SUBJECT: BEACH APARTMENTS BARR DRAIN LICENSES (J-12/DB)

SUBJECT: BEACH APARTMENTS BARR DRAIN LICENSES

RE: CERTIFICATION FOR PHASE II OF THE BEACH APARTMENTS
ENGINEERS STAMP DATED DECEMBER 19, 1985 (J-12/D8)

PROJECT TITLE: THE BEACH APARTMENTS ZONE ATLAS/DRNG.FILE #: J-12/DB

1 STORM SEWER DISCHARGE STRUCTURE

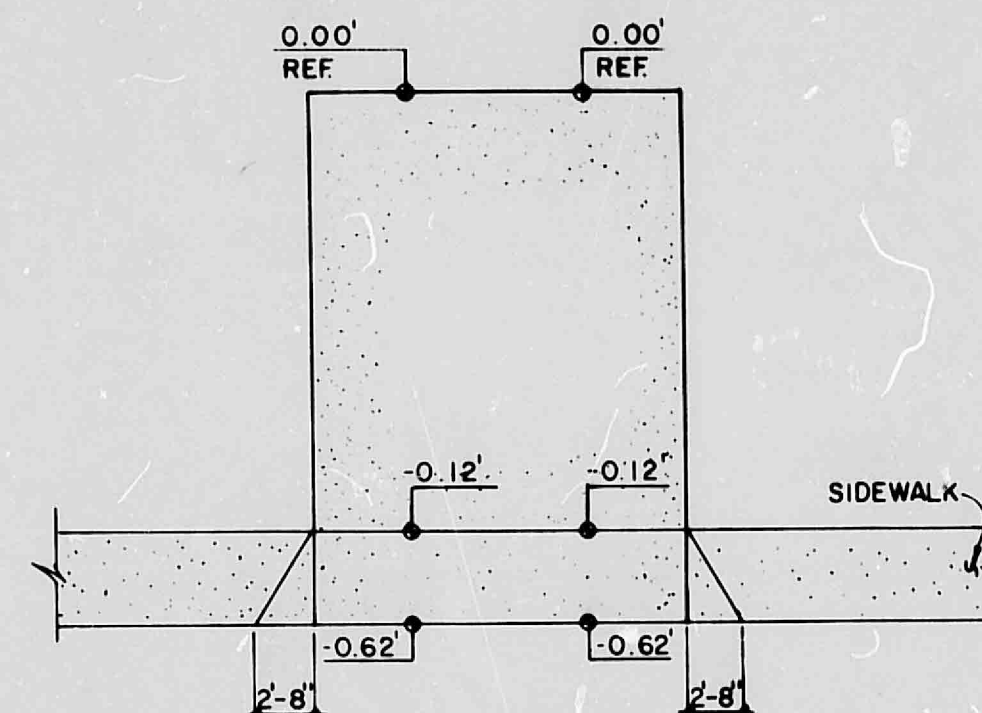
1. Both licenses are for 12" Ø Reinforced Concrete Pipe. Neither installation is Reinforced Concrete Pipe.
2. Minimum requirements for riprap are not to the standards shown on approved drawings.
3. The fence appears to encroach on the drains right-of-way. Any encroachment must be removed or licensed.
4. Rubbish from construction of Beach Venture, LTD's apartment construction was dumped upon the Middle Rio Grande Conservancy District's (MRGCD) right-of-way.

1. Please address the stability of the drain bank to erosion. The velocities and discharge should be determined to show if the apartments or parking is subject to structural problem from erosion.
2. Require a copy of the permit from the Bureau of Reclamation to discharge to the drains prior to release of Building Permit.
3. The Bureau of Reclamation has required a different rundown, therefore, please submit the new drawing to us.

2. A copy of the permit from the Bureau of Reclamation will be sent to you as soon as we receive a copy.
3. Enclosed is the revision of the rundown.

The 2-foot extension has been revised to 3 feet minimum. The stability of the rundowns are adequate because the 100-year velocity is only 3.4 ft./sec. maximum.

PHASE II - ENGINEER'S CERTIFICATION

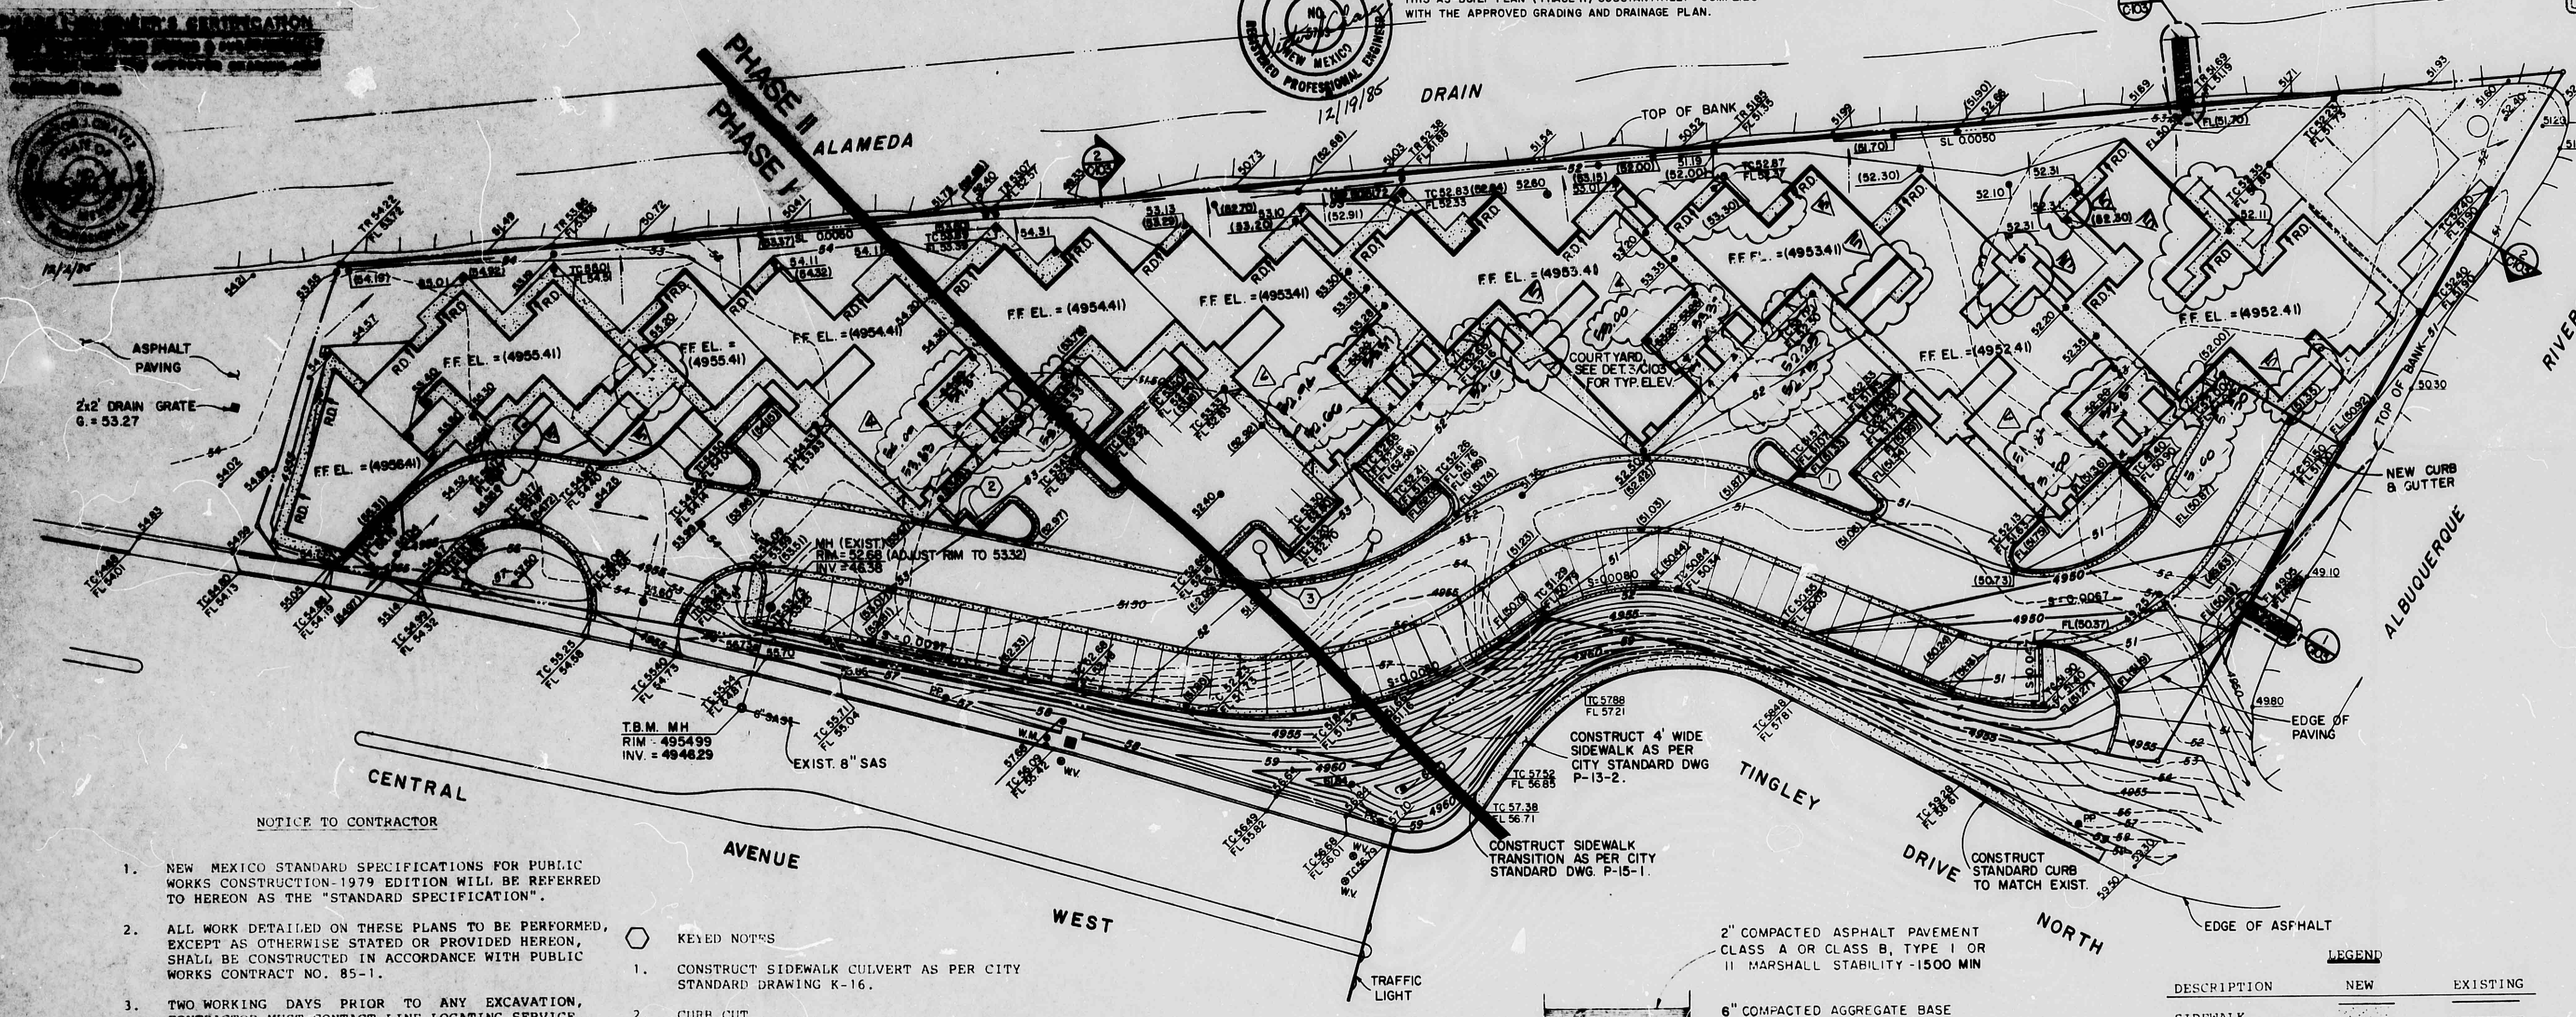
1. I do not find in the submittal that utilization of the Alameda and Riverside Drains as an outfall has been granted by the appropriate controlling agency. *in record*
2. Stability of the banks of the drains abutting the property has not been addressed.
3. The hydraulics and design information associated with the rundown have not been provided. I do not feel that the two (2) feet of extension in the channel is adequate. That area is an energy dissipation point and is highly susceptible to erosion, undercutting and failure. The information has not been provided to determine the stability of this proposed rundown.
4. The plan is not drawn to standard, i.e., it is upside down and the scale is wrong.

5. I cannot decipher what the construction plan is for the SW corner of the site. How is the curb and gutter, sidewalk and entrance supposed to tie in to Tingley Drive North?
6. The roof drain locations need to be shown on the plan.

4. The plan is drawn as shown in order to fit on the standard 24" x 36" sheet and be legible and also to match the architects site plan. The plan is "upside down" to match the architects site plan.
5. The construction plan for the southwest corner of the site is an emergency exit only which was requested and approved by the Albuquerque Fire Department. The sidewalk and curb and gutter were requested by the City Traffic Department.

6. The roof drain locations have been added to the plan.
